From: [GOVE, Michael](#)
To: [Southampton to London Pipeline Project](#)
Subject: Esso Pipeline
Date: 08 April 2020 18:23:22
Attachments: [The SLP - Response to the revised SSP for Turfhill Final V3 160320.docx](#)
[The SLP - Decision for Inspectorate re IROPI Test for Applicant Final 160320.docx](#)
[Surrey Heath Borough Council Deadline 7 Submission.pdf](#)

The SLP – Heronscourt & Colville Gardens (the RAs) response to the Applicant's Revision 2.0 of Site Specific Plan APP Document 8.58 dated March 2020

## **Appendix B – Construction and Reinstatement Plans**

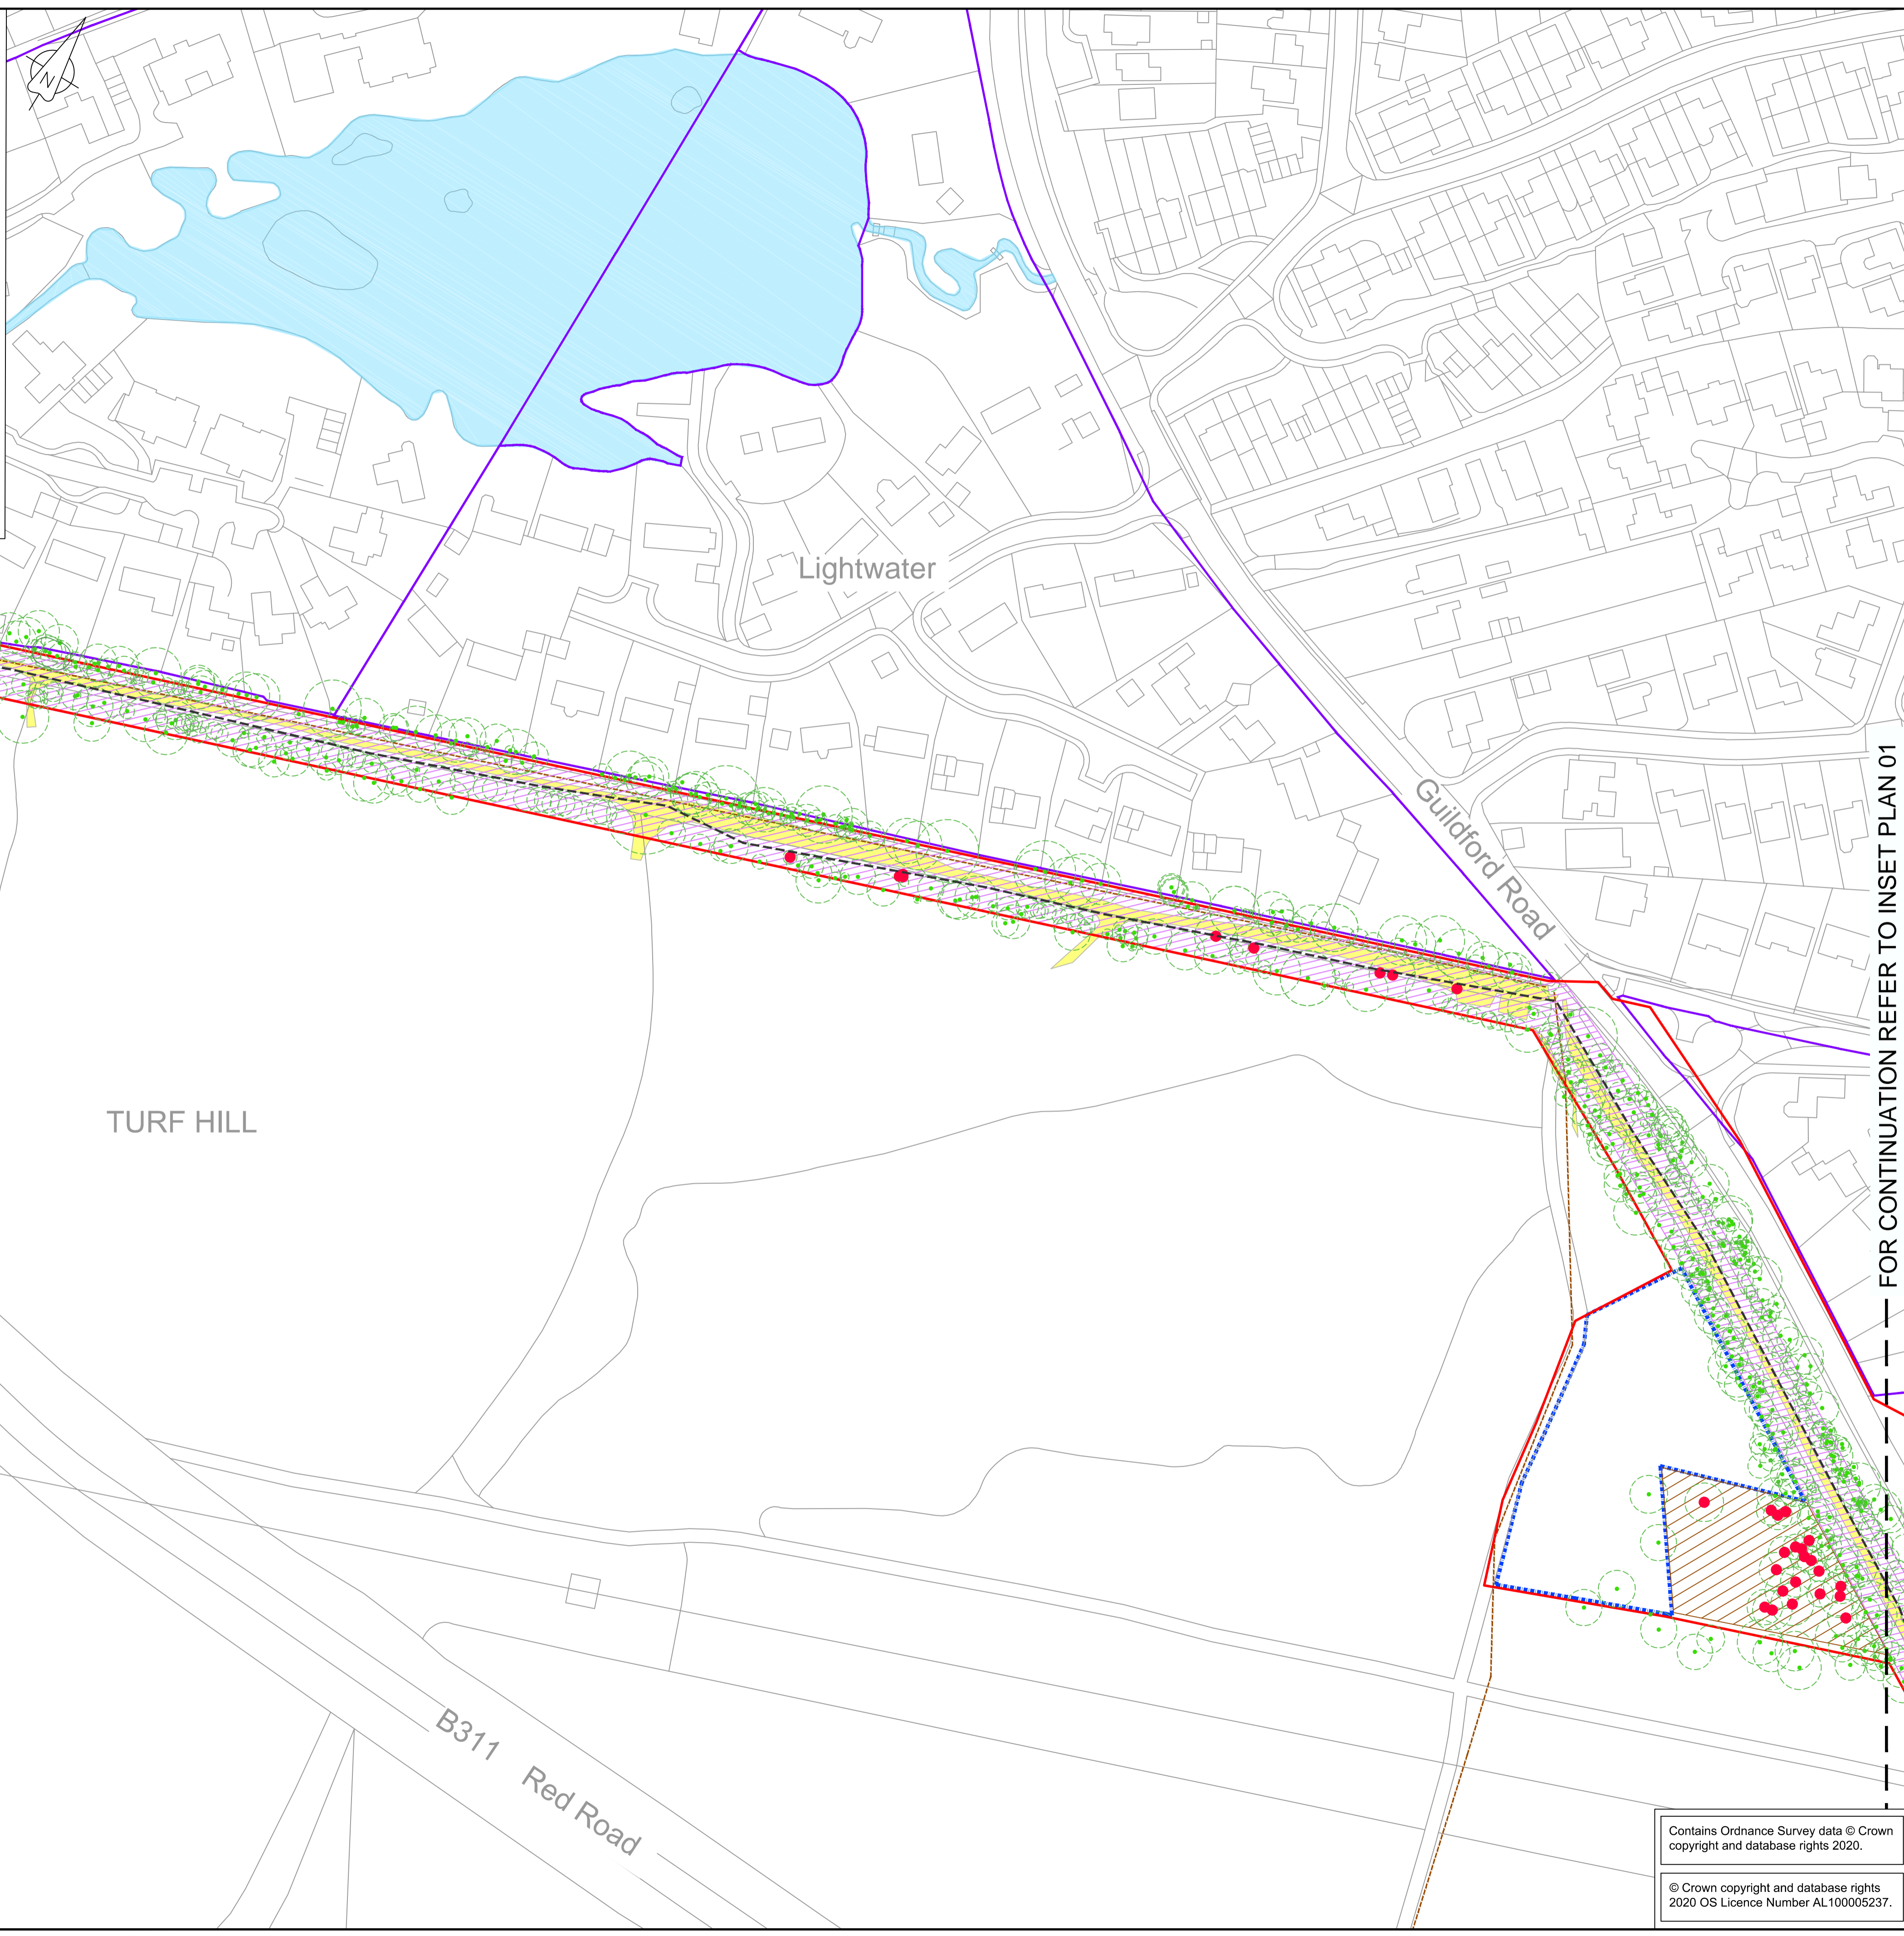
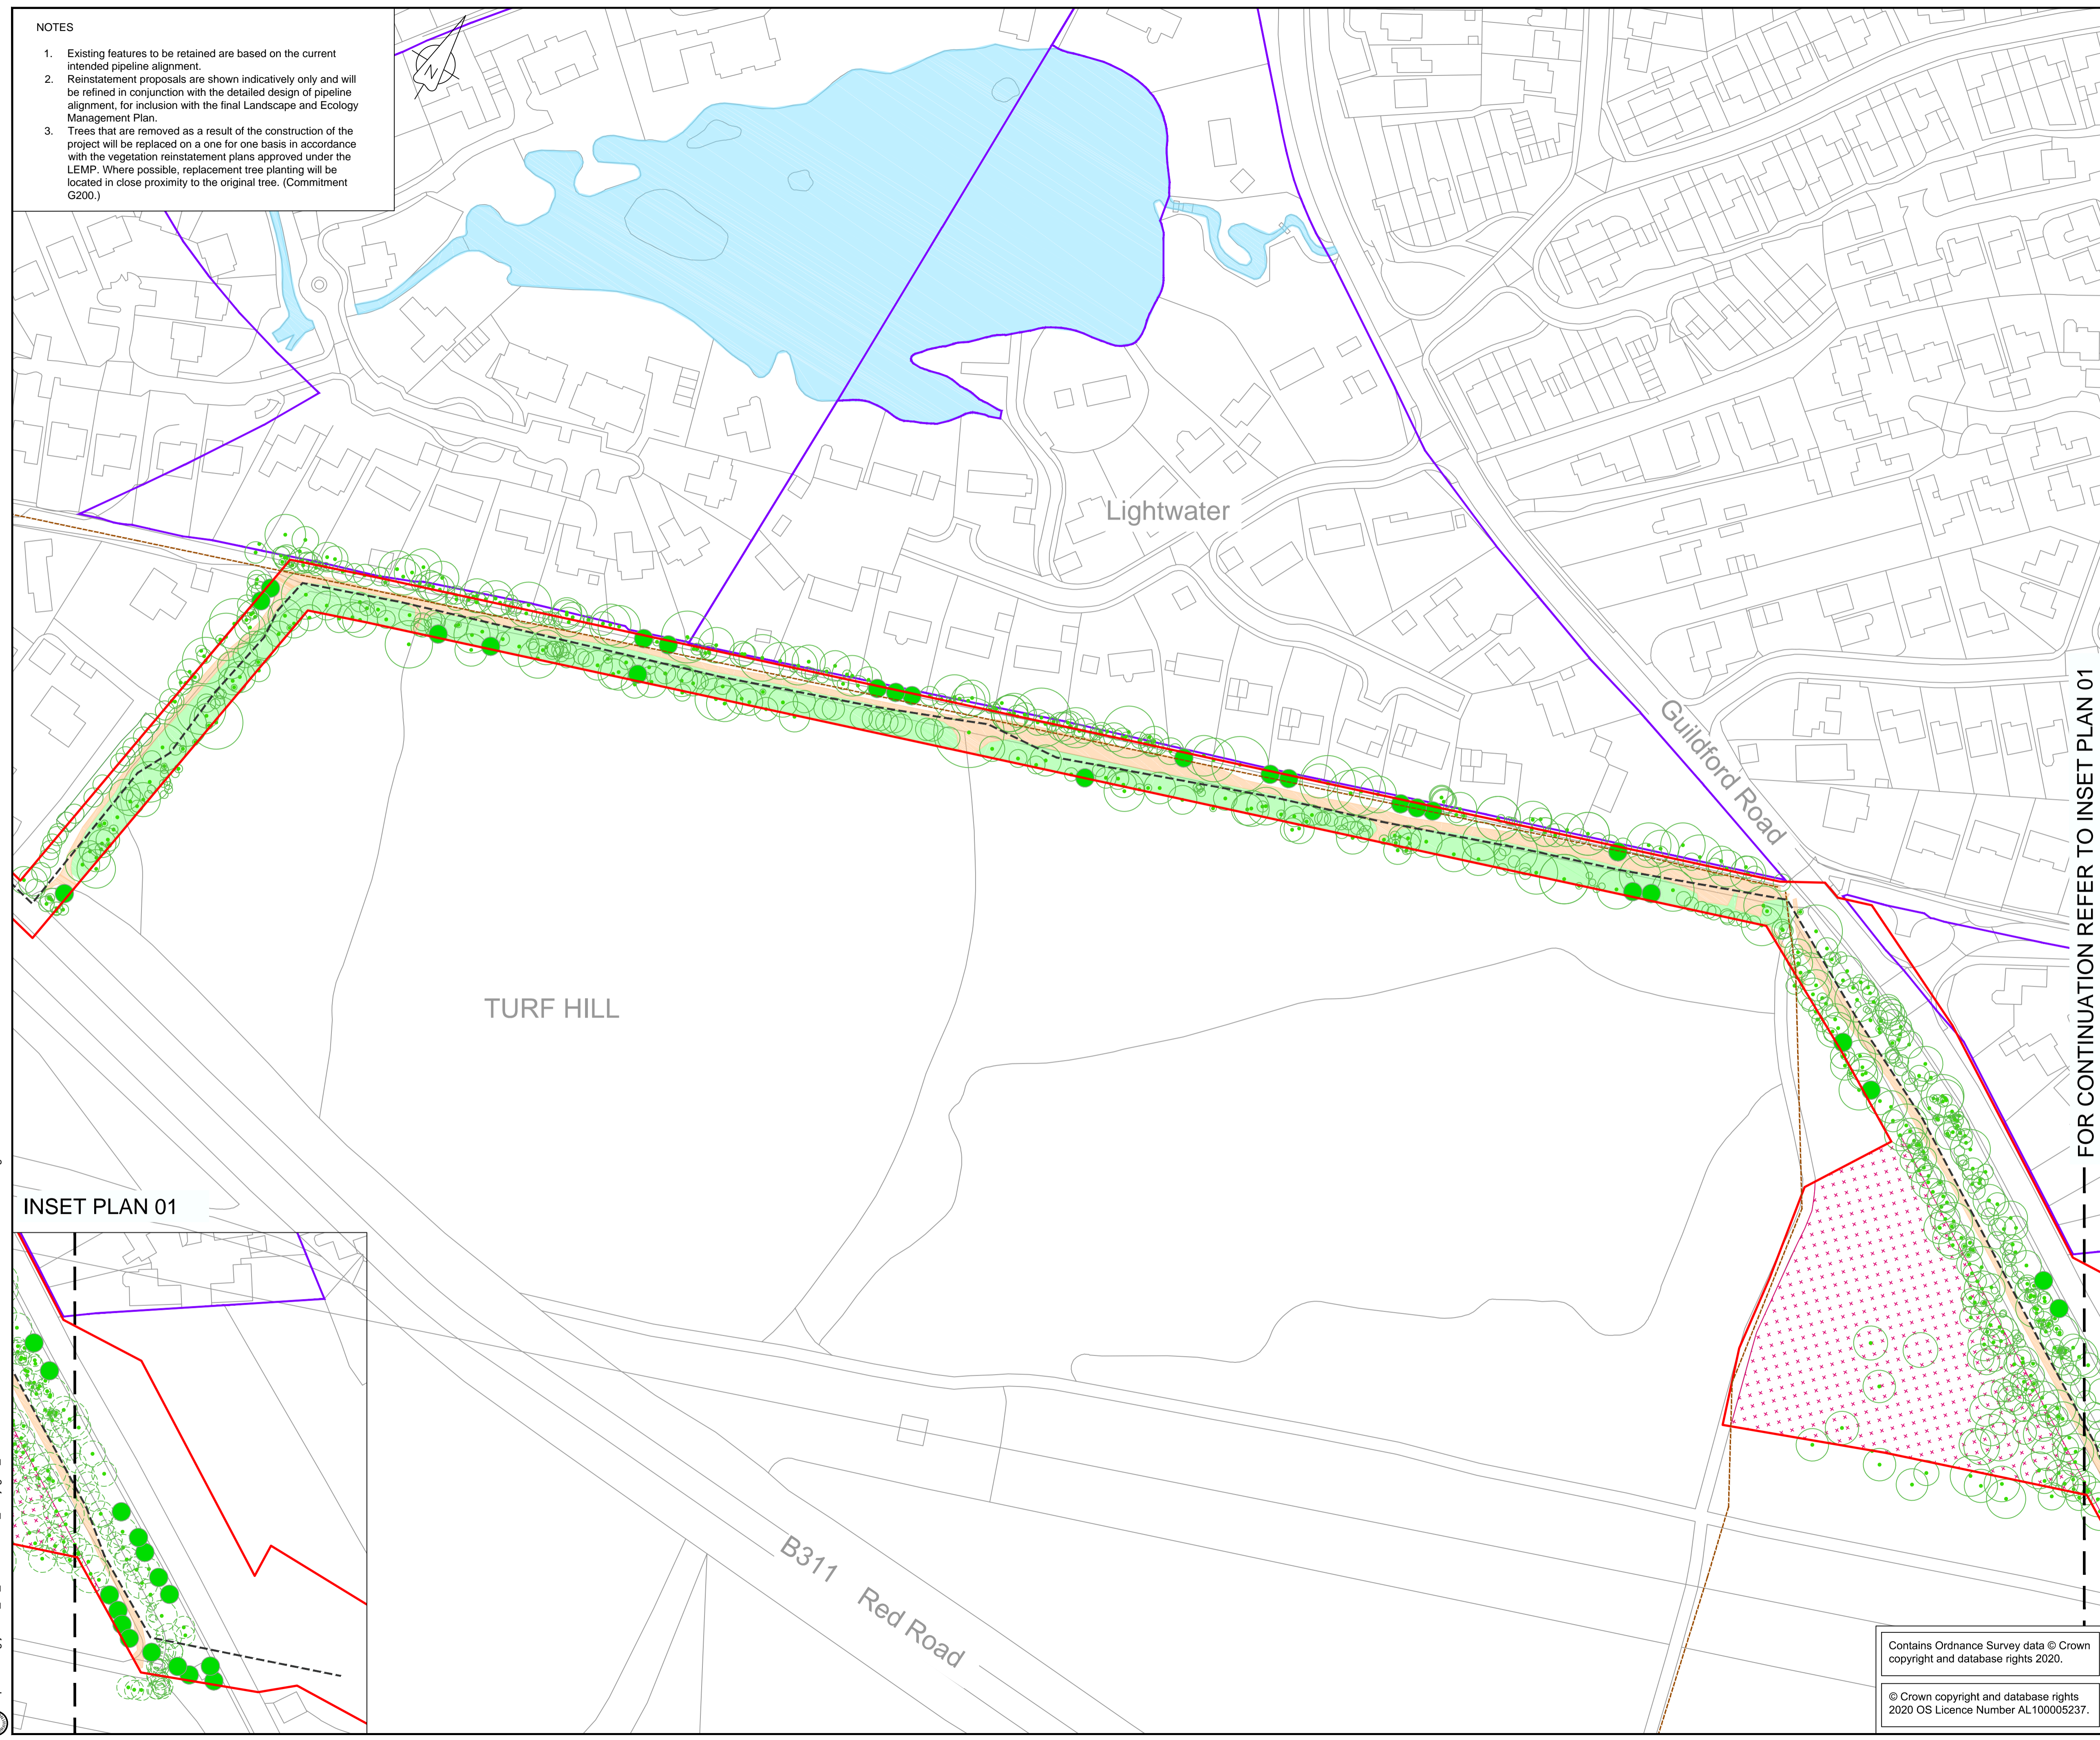
Appendix B Construction and Reinstatement Plans

There are obvious comments which need to be made;

- F1a is not a straight pathway and curves away out of sight from the Guildford Road, northwards at approximately midpoint and pipelines do not bend in straight lines!

- it makes no mention of the water main, unless the dotted red line is meant to indicate its position and which, in the absence of any actual survey, can only be an optimistic guess.

- even given that the RPAs of retained and bordering trees are shown using minimum calculations, the proposed line cuts through a considerable number of them. In some cases, it runs nearly through the middle of the indicated RPA. No apology is made for reiterating a statement made in the RAs response to the first SSP, that an RPA is not 'a no damage likely to be done' but is more 'a tree is unlikely to die immediately and may eventually recover.'

- at approximately midpoint, along the northern boundary, the line comes extremely close to a number of properties, in particular Nos 29 & 31 of Heronscourt and No 20 of Colville Gardens, where there are very substantial trees bordering F1a.
